Ribble Valley Borough Council
Housing & Development Control

Your ref: 3/2024/0393
Our ref: D3.2024.0393
Date: 27th June 2024

Application no: **3/2024/0393**

Proposal: **Approval of details reserved by conditions 3 (materials), 7 (SW and FW drainage schemes), 10 (elevational streetscene details), 11 (drawings of proposed retaining wall), 13 (construction management plan) and 15 (details of existing and proposed ground levels) from planning permission 3/2023/0866.**

PROJECT		DRAWING TITLE	
PLOT 11 HARE HILL CROFT, CHATBURN OLD ROAD		CONSTRUCTION MANAGEMENT	
CLIENT	MR R JACKSON	SCALE	1:1
DATE	APR 23	JOB REF	001
DRN BY	AM	DRAWING NUMBER	PLOT11DOCCEMP
WKS	@A1	REV	B

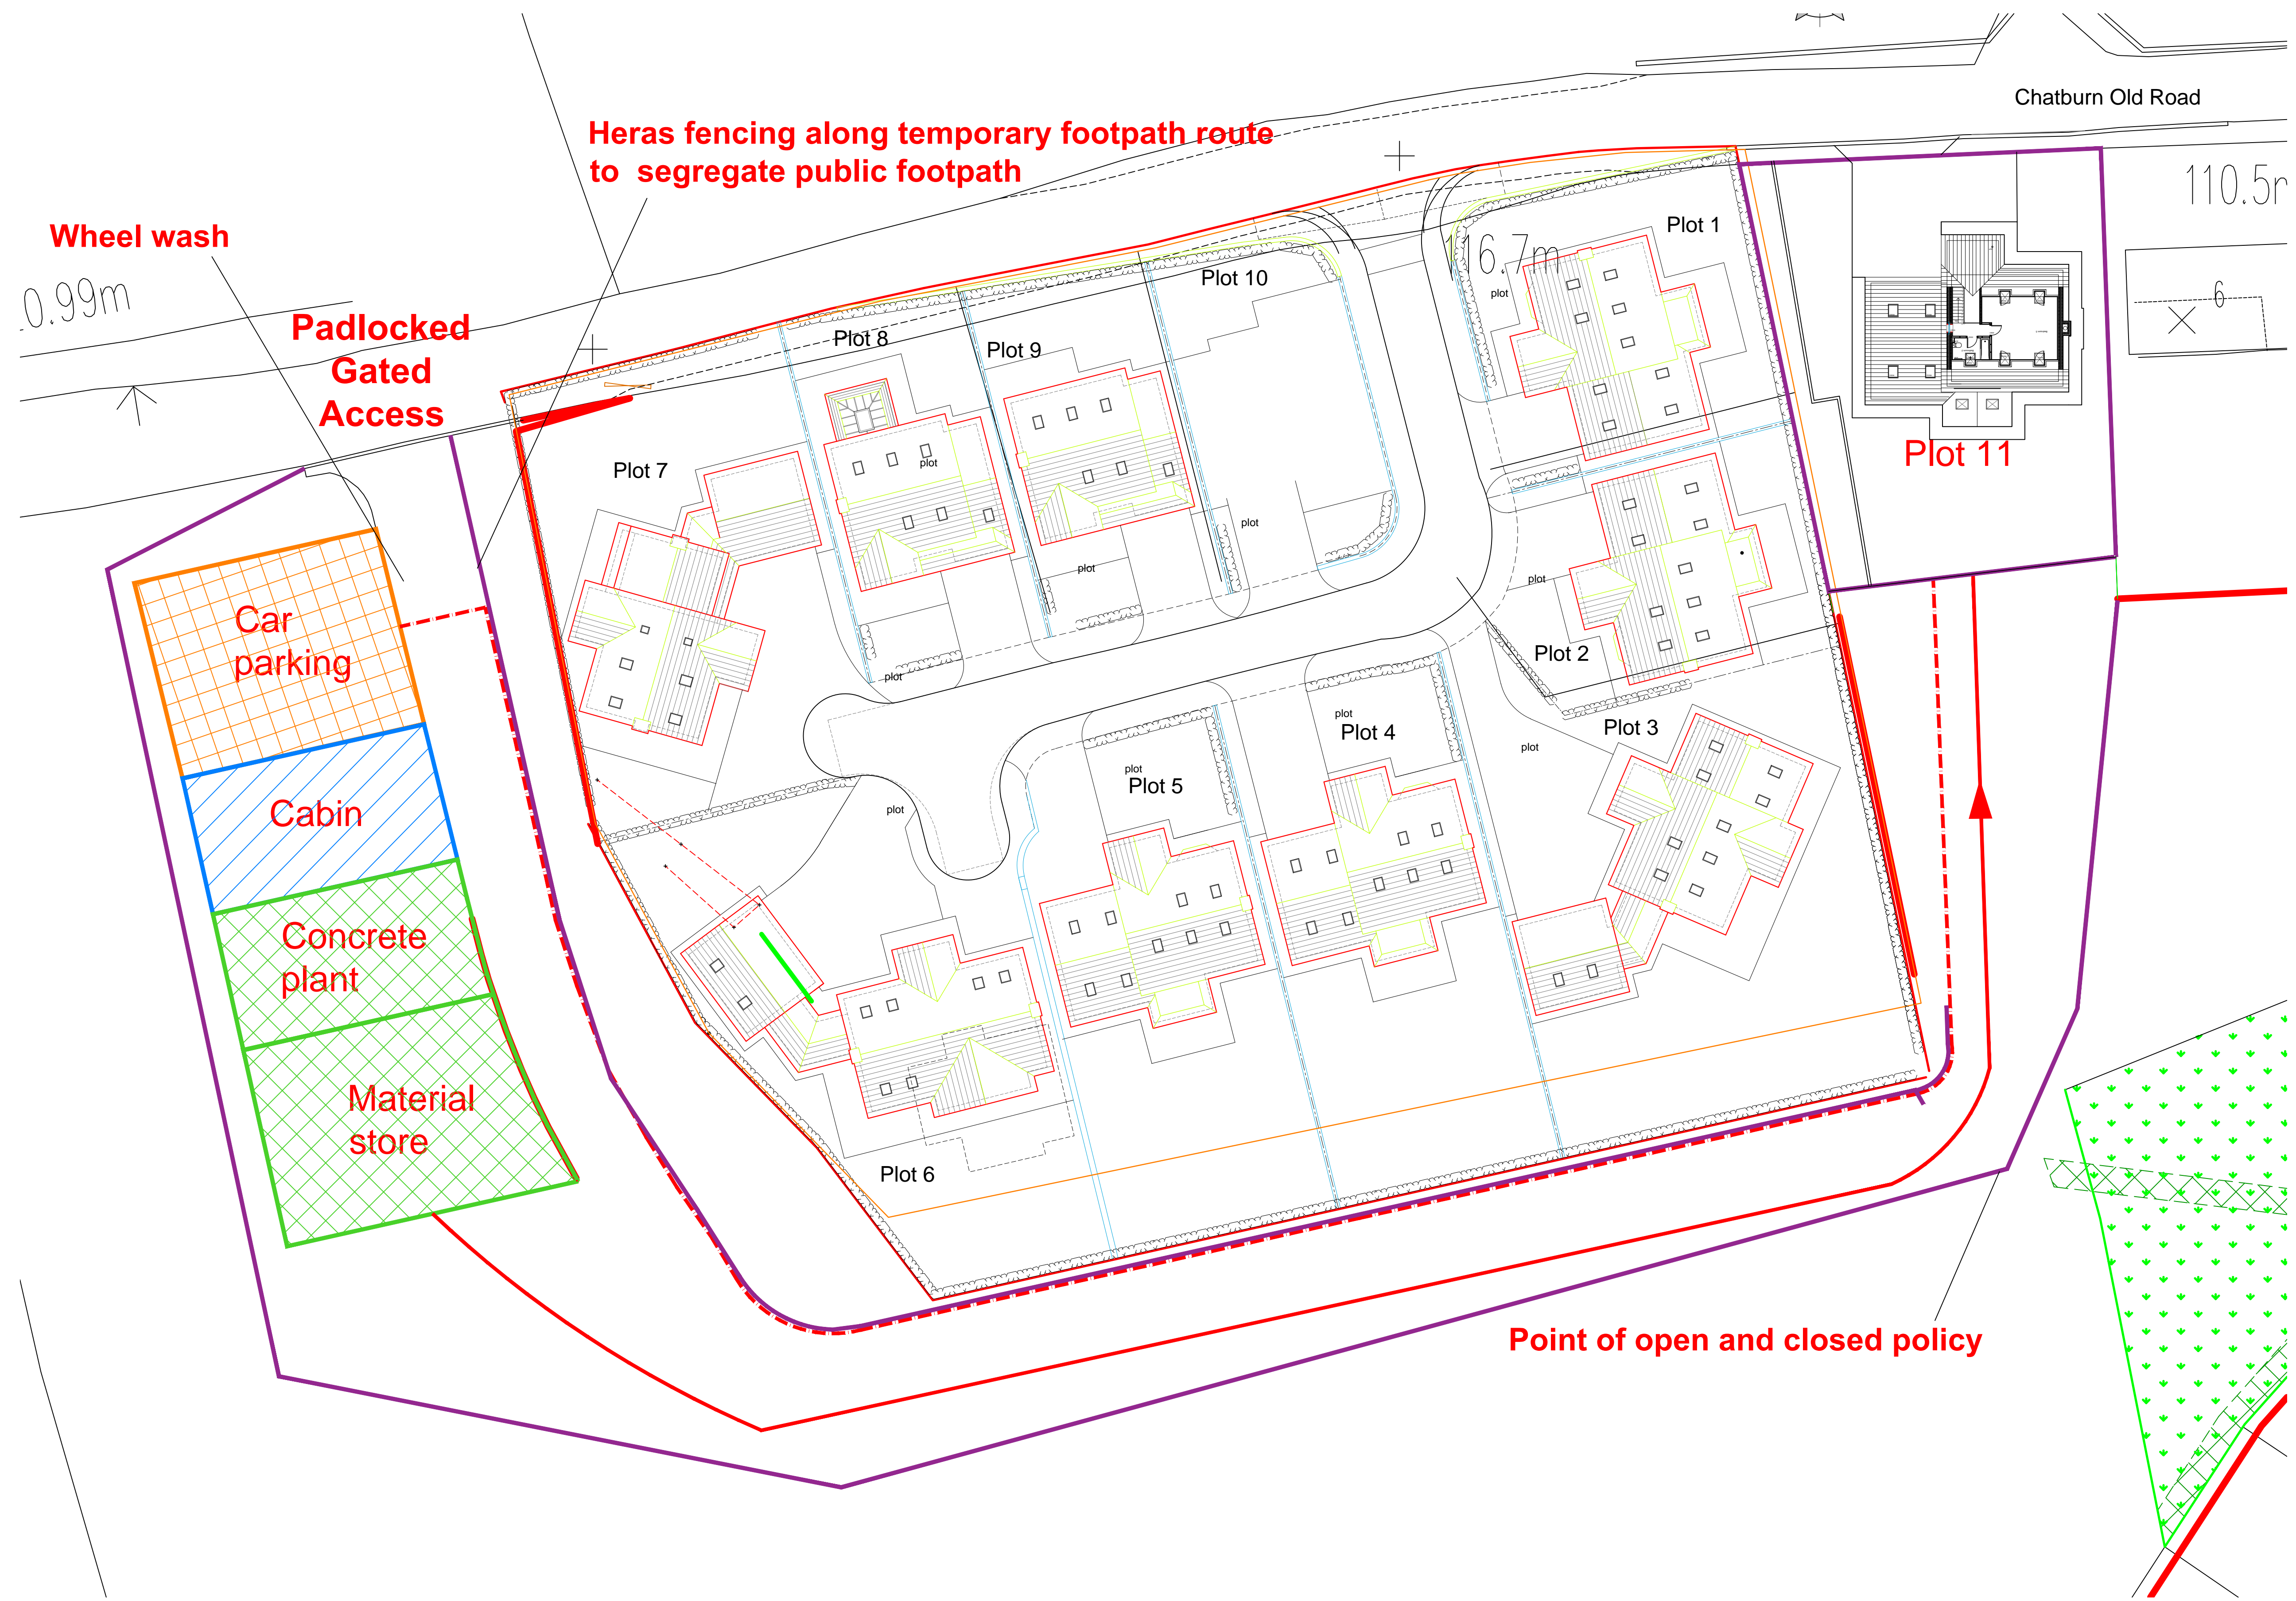
The LHA as currently presented object to the discharge of condition. This is because firstly the LHA require further information regarding the compound area, as shown on drawing number PLOT11/DOC/CEMP Rev D titled "Construction Management", which is located separately from the site. The LHA require further information regarding whether the Applicant owns the site as well as the proposed compound site or whether an agreement with the landowner has been found to use the area for a temporary period.

Secondly, the LHA require the compound plan to show where Public Footpath FP0311013 is located. The LHA need to ensure that measures are put in place to ensure that the

Public Footpath can still be used during the construction phase or if not, a temporary closure is required.

Should the Public Footpath be open during construction, the LHA require construction signs to be implemented along the Public Footpath where the route narrows, as it approaches the rear of the construction site. The LHA also need to ensure that users of the Public Footpath can continue to easily access the route for the full duration of its length, with the LHA being concerned that the erection of hoardings may prevent pedestrians from using the Public Footpath at the rear of the site. Therefore, further information is required.
